Application number: 2026/62/90452/E	
What is the application for?:	Erection of dwelling and associated works
Address of the site or building:	Land adj, Lower Common Lane, Scissett, Huddersfield, HD8 9HL
Postcode:

Type of comment: An objection	
Do you wish your comments to be published on the website anonymously?	Yes

Proposed Site Plan 1:200

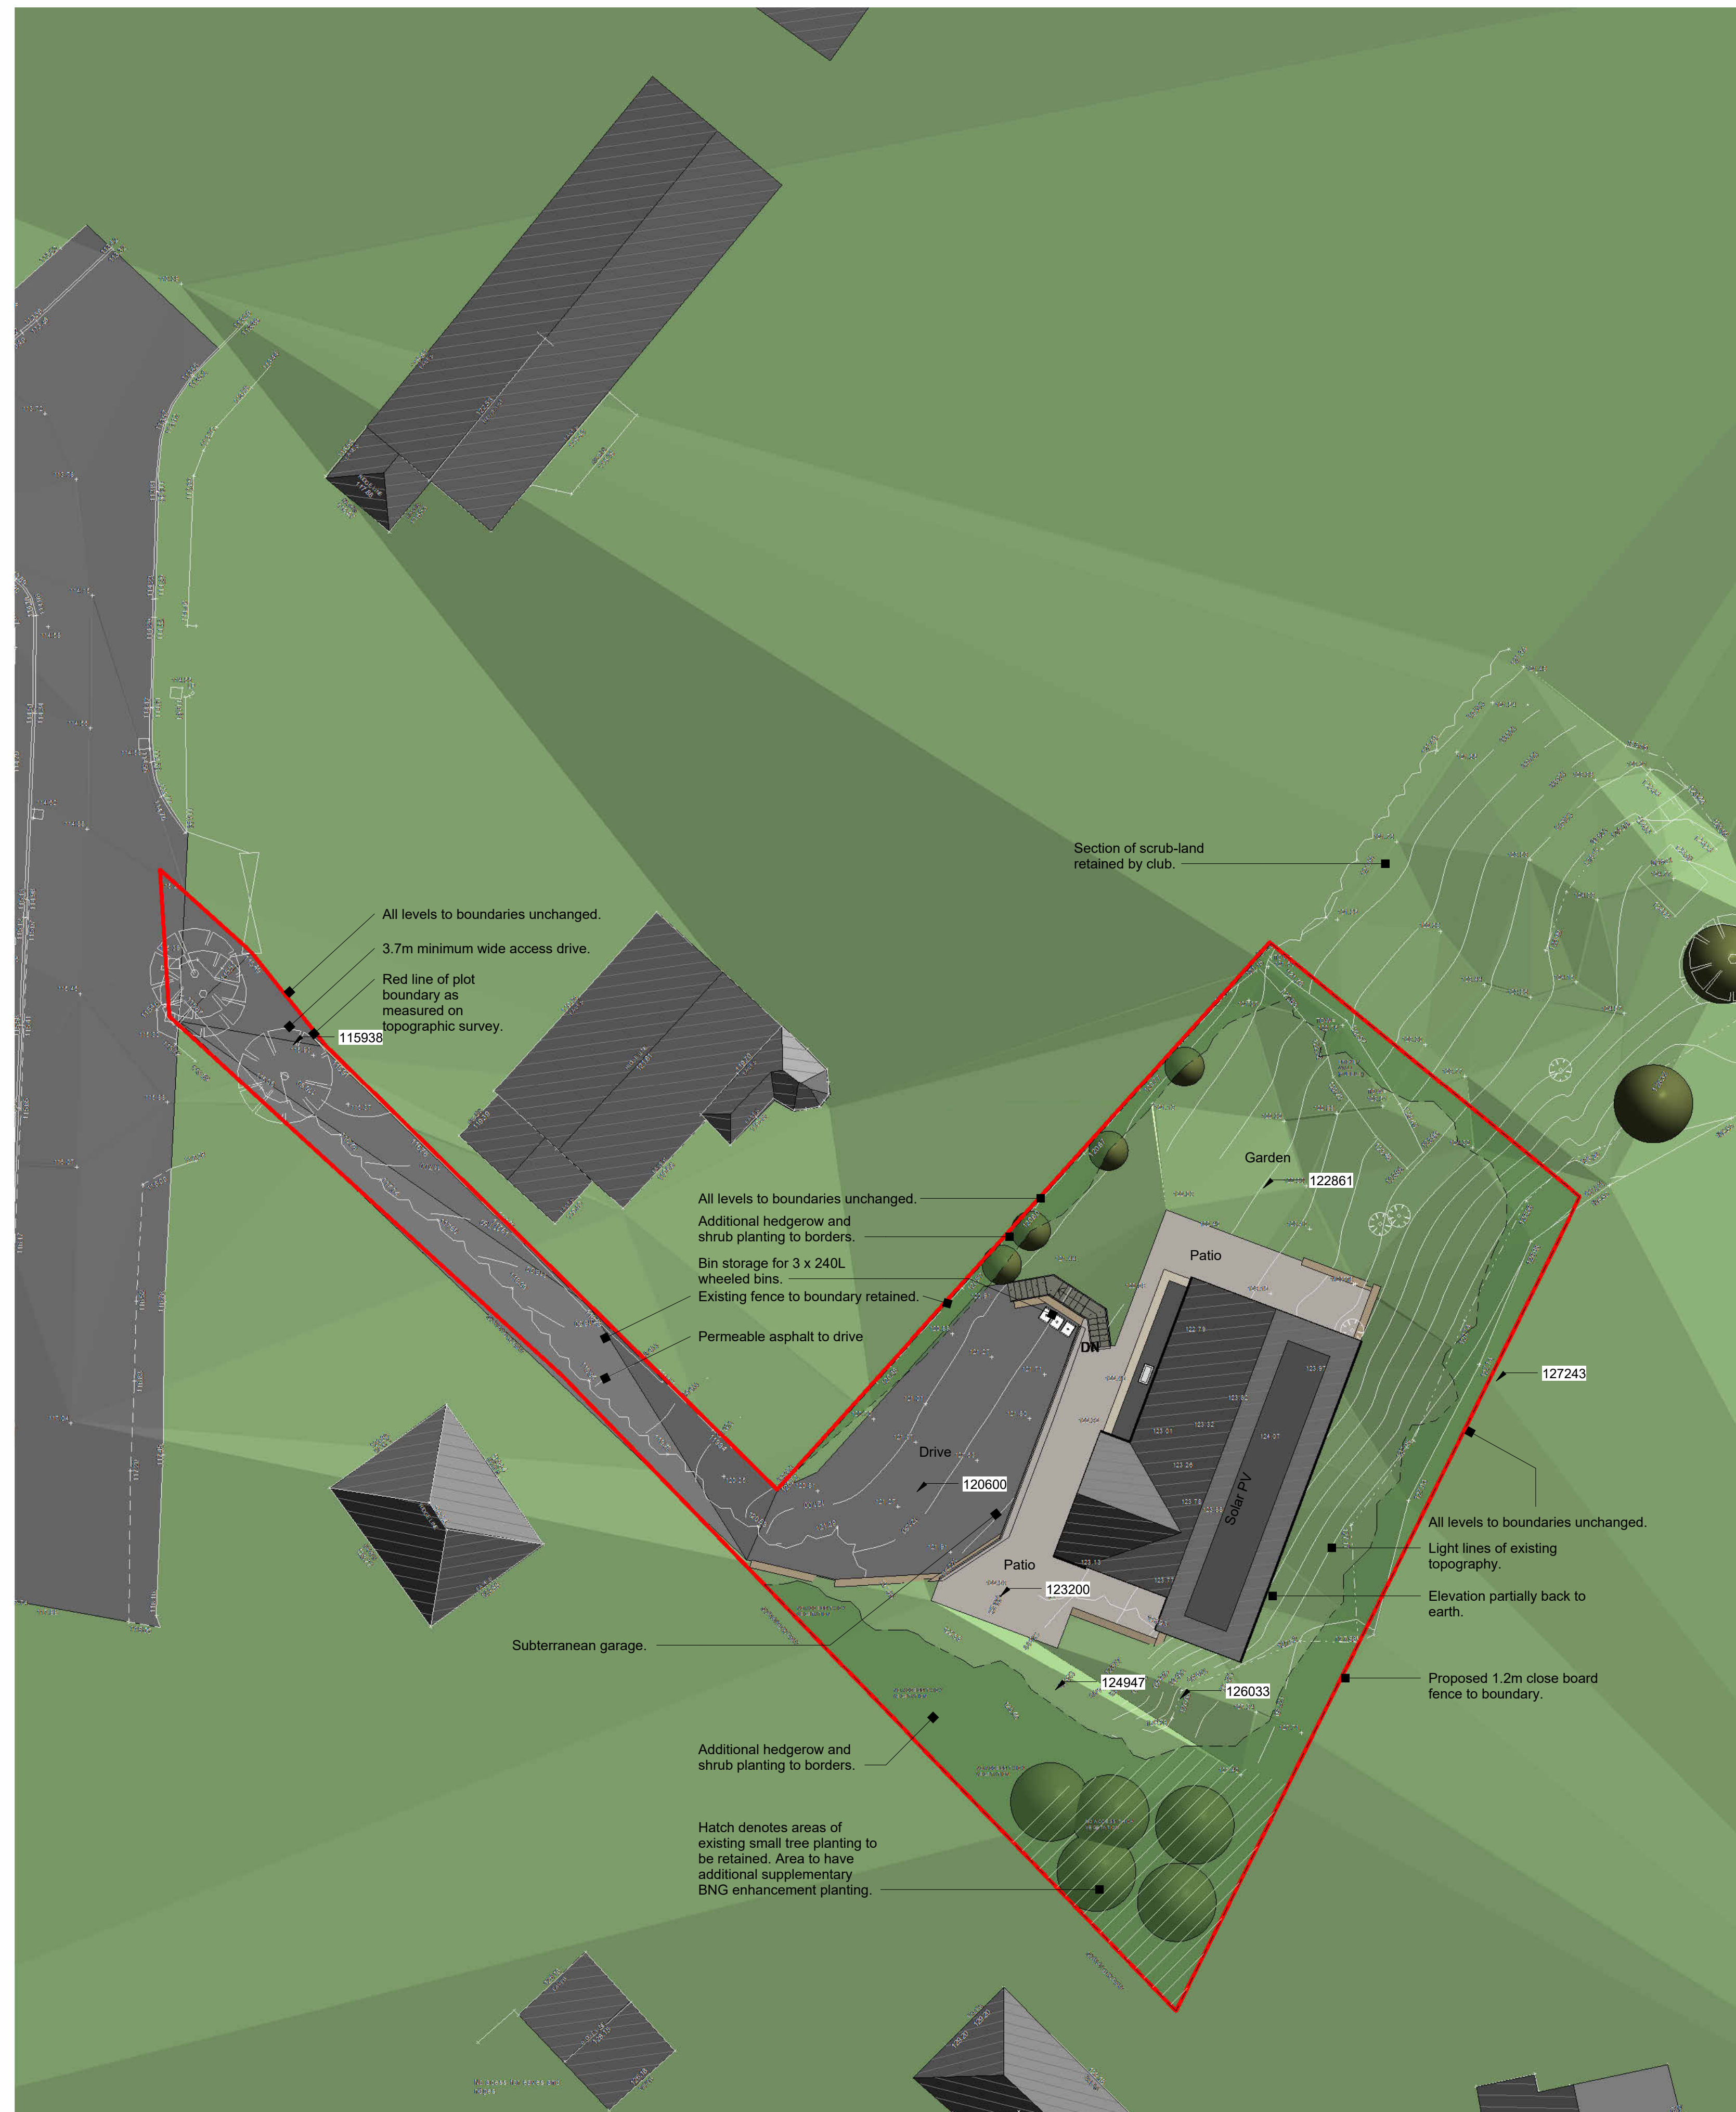
1. The actual entry point on Lower Common Lane. This is between a stone wall belonging to Laurel Bank and the open driveway to the bungalow at no.1. How are the these two driveways to be kept separate especially during construction.

2. The 12ft width of the existing pathway is bordered by a mixed mature hedgerow with an undefined boundary to one side and a wooden fence on the other making it a corridor with limited visibility.

3. The incline up towards the opening out of the site gets steeper over the 45m access with a sharp left turn into the site behind the boundary fence of no. 1. Again making visibility a problem. The area on the boundary side of the garage at Laurel Bank has a substantial drop off which will require a retaining wall along the proposed access.

4. This 12ft wide access pathway and an 8ft strip behind the boundary fence carries a private easement therefore how are pedestrians and vehicles to be safely kept apart.

6. The building site itself will prove difficult to manage because of the size of the development in ratio to size of the land. How will machinery and supplies be stored whilst building in a confined space. At groundworks stage how will lorries manoeuvre alongside other equipment and enter or egress the site safely .This may mean smaller delivery lorries but that means more visits. This proposed access is single file traffic and the length again causes visibility issues and dangerous reversing manoeuvres at all stages of use. Vehicles will inevitably have to queue on Lower Common Lane opposite Hillside House Day Nursery to enter the site.
